Please ask for: Nicola Moore
Email: nicola.moore@arun.gov.uk
Telephone: Ext 37944
Our Ref: BE/97/21/PL
Your Ref:
Date: 17th June 2021

Application for Planning Permission

Development: 1 No. dwelling
Location: Springfields Chichester Road Bersted PO21 5EE

POINT 227E

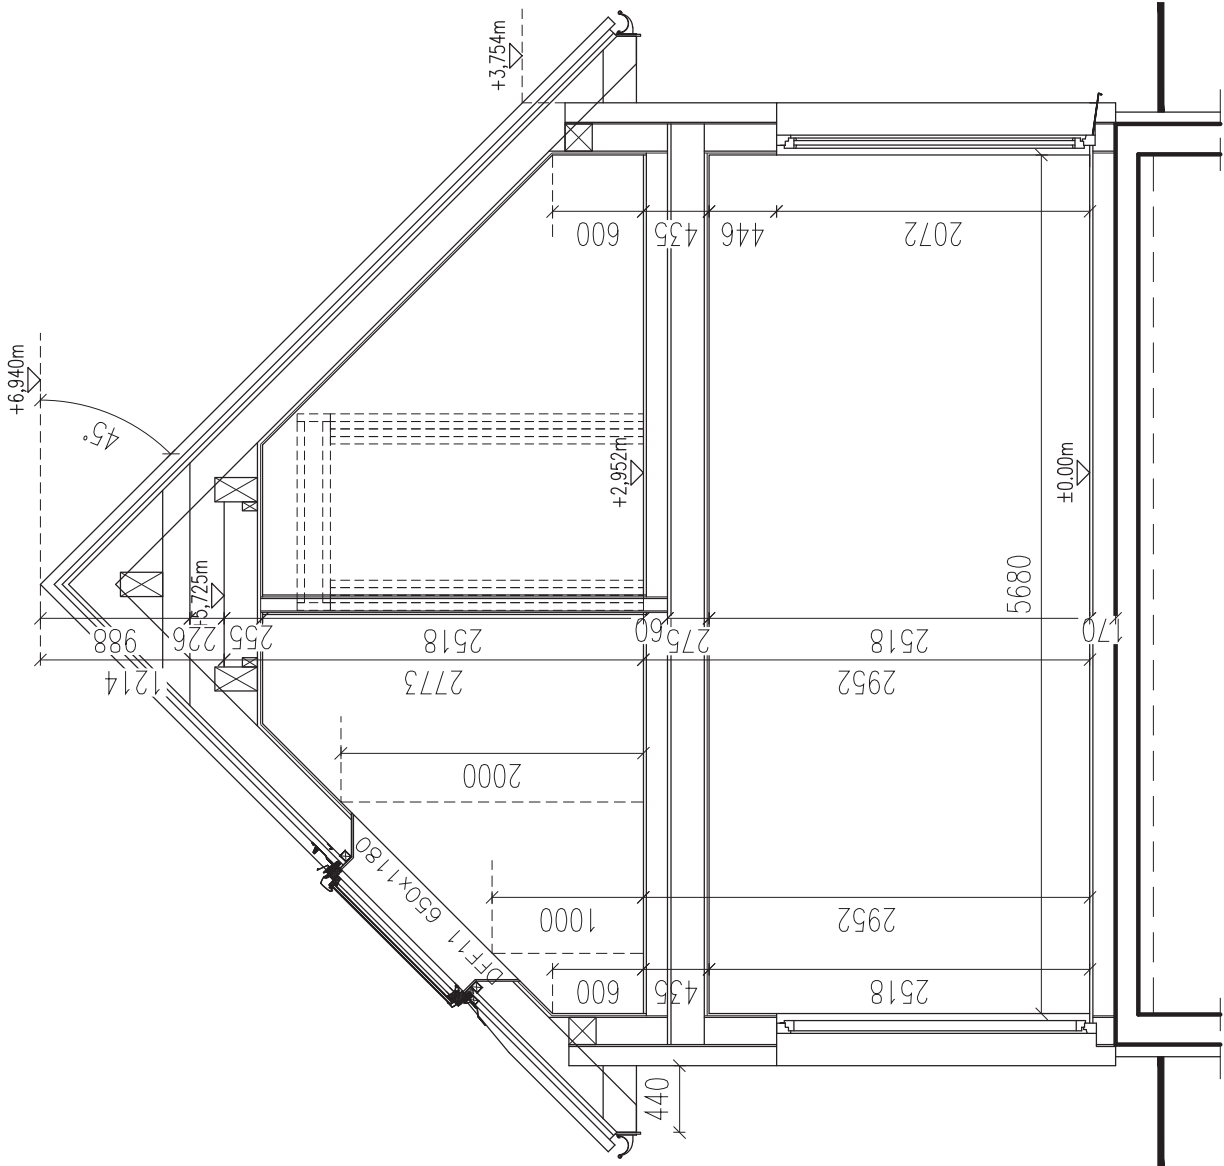
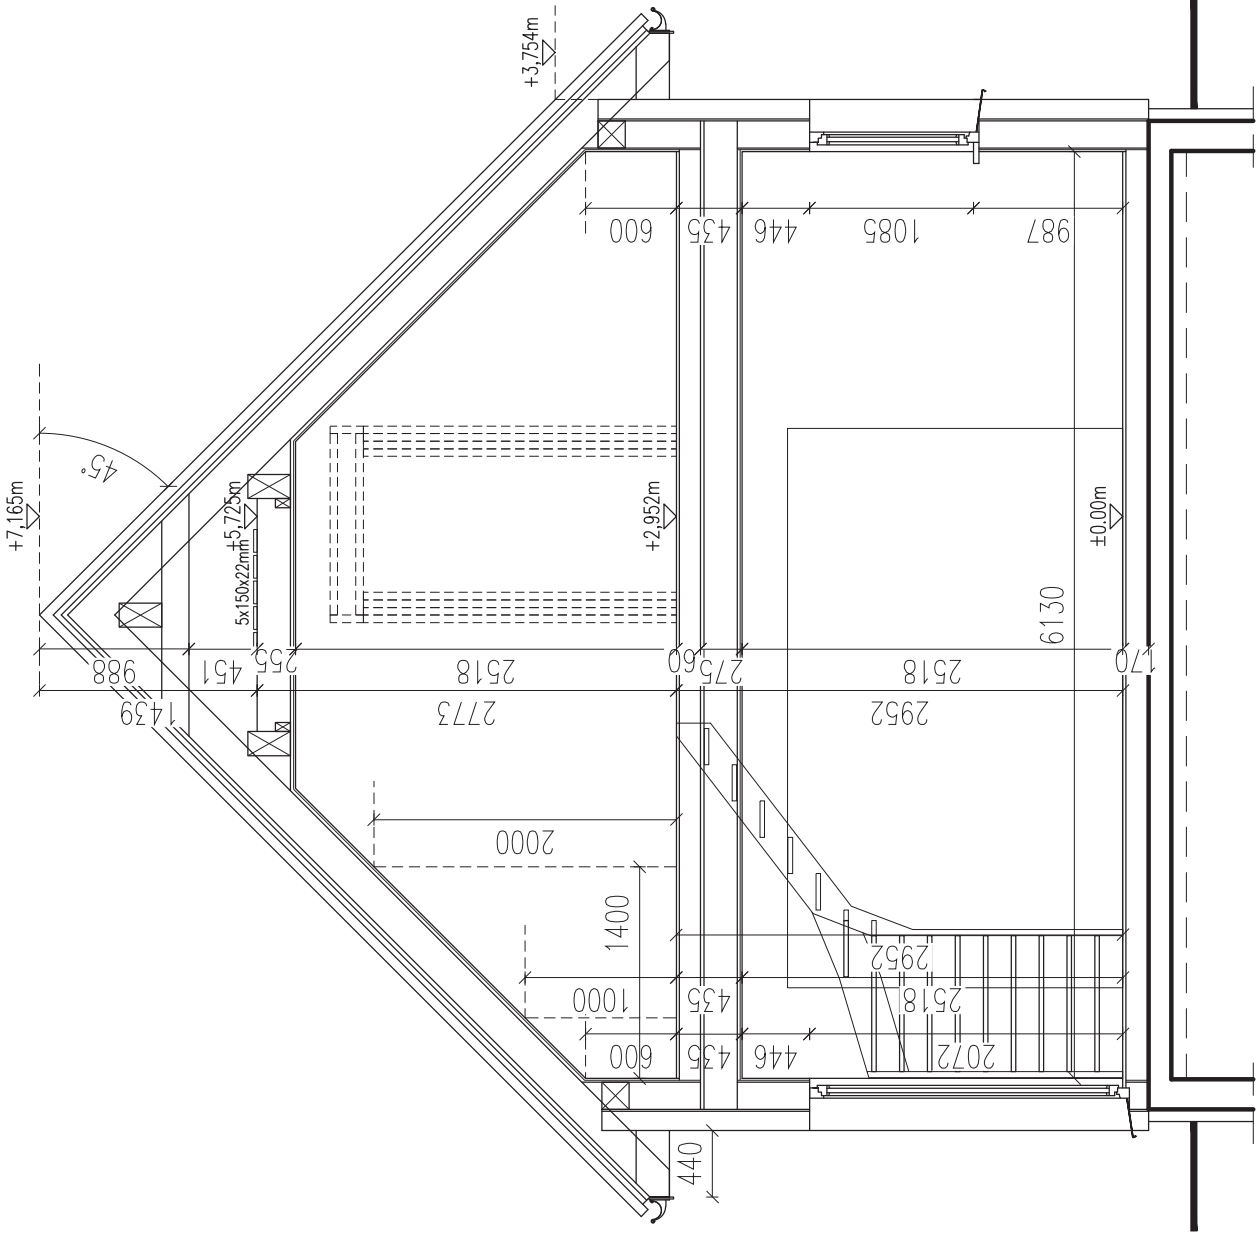
We are unable to scale the submitted floor plans at 1:75. Please re submit at 1:50 or 1:100.
